**KIRKLEES METROPOLITAN COUNCIL  
INVESTMENT & REGENERATION SERVICE**

**DELEGATED DECISION TO DETERMINE PLANNING APPLICATIONS**

Reference No:	<b>2024/62/92351/W</b>
Site Address:	Whinney Close Farm, 106, Cockley Hill Lane, Kirkheaton, Huddersfield, HD5 0PF
Description:	Erection of detached dwelling and associated landscaping
Recommending Officer:	Lucy Taylor

**DECISION – REFUSED**

Figure 1.4 Proposed Site Plan (Not to scale)

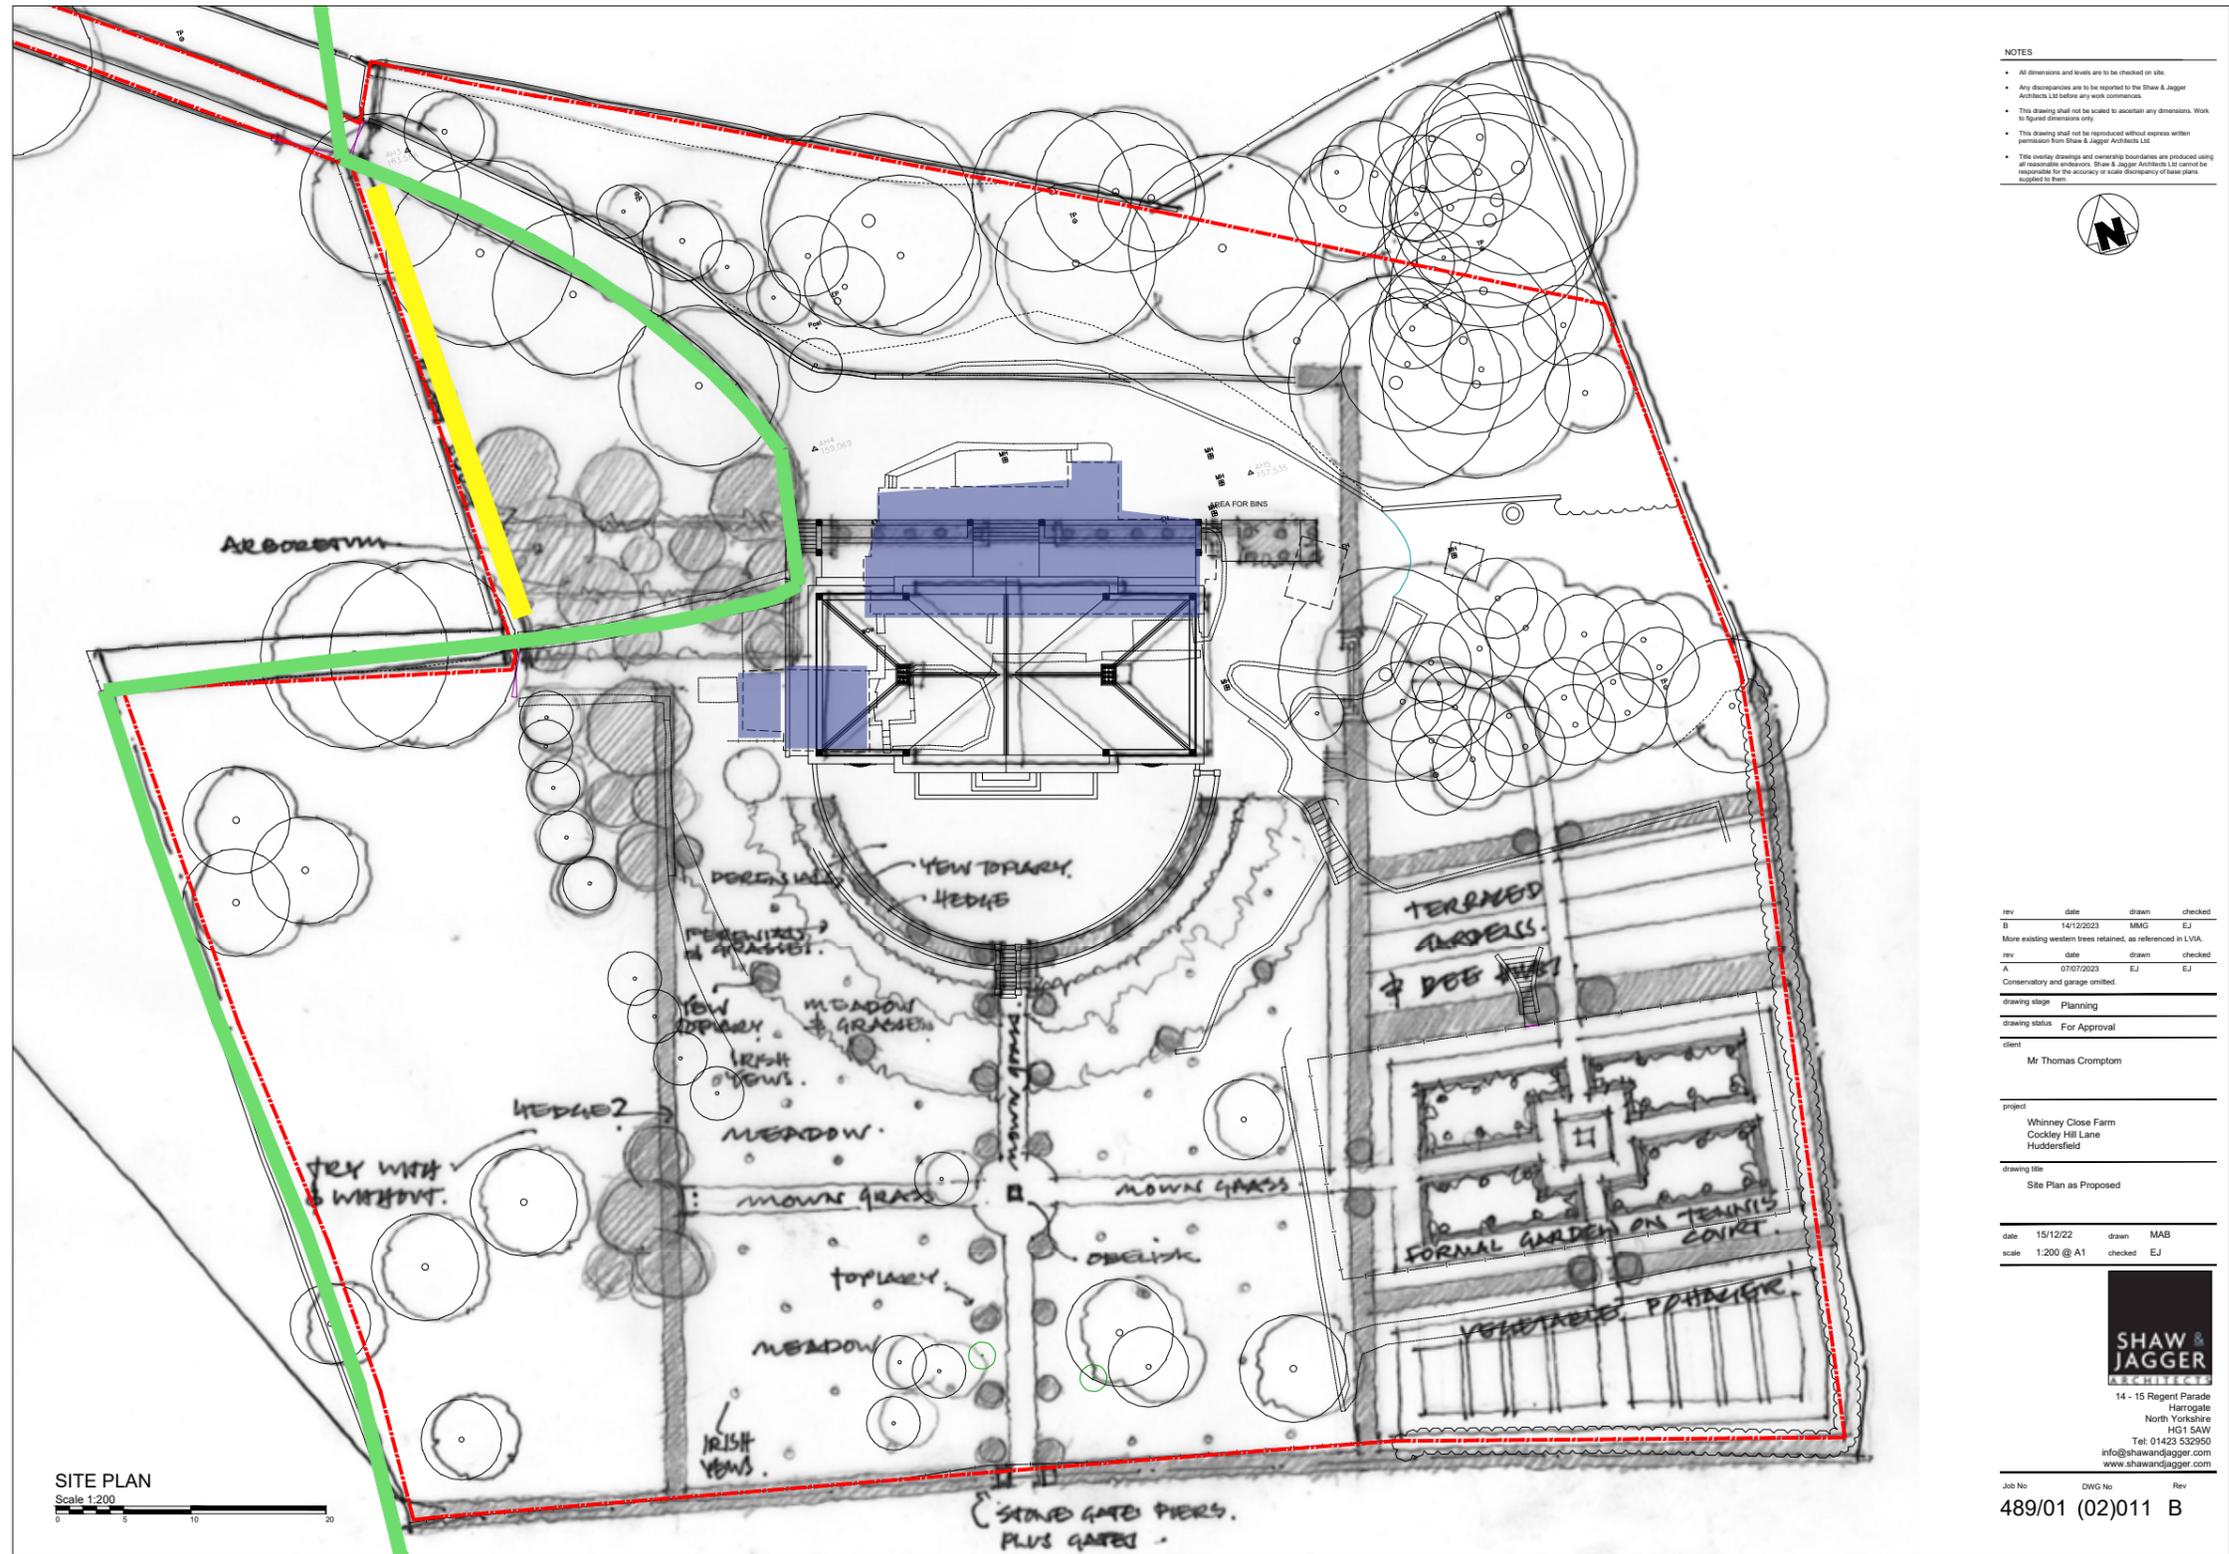
The route of the public right of way which crosses the site is indicated as being re-routed along an alignment which it appears to currently be utilised. The area of the public right of way which is upon the Council's records appears unaffected upon the submitted site plan (ref: 006RevB).

**KC PROW** (informal) – The current plans do not show how the existing footpath can be incorporated in the proposed landscaping.
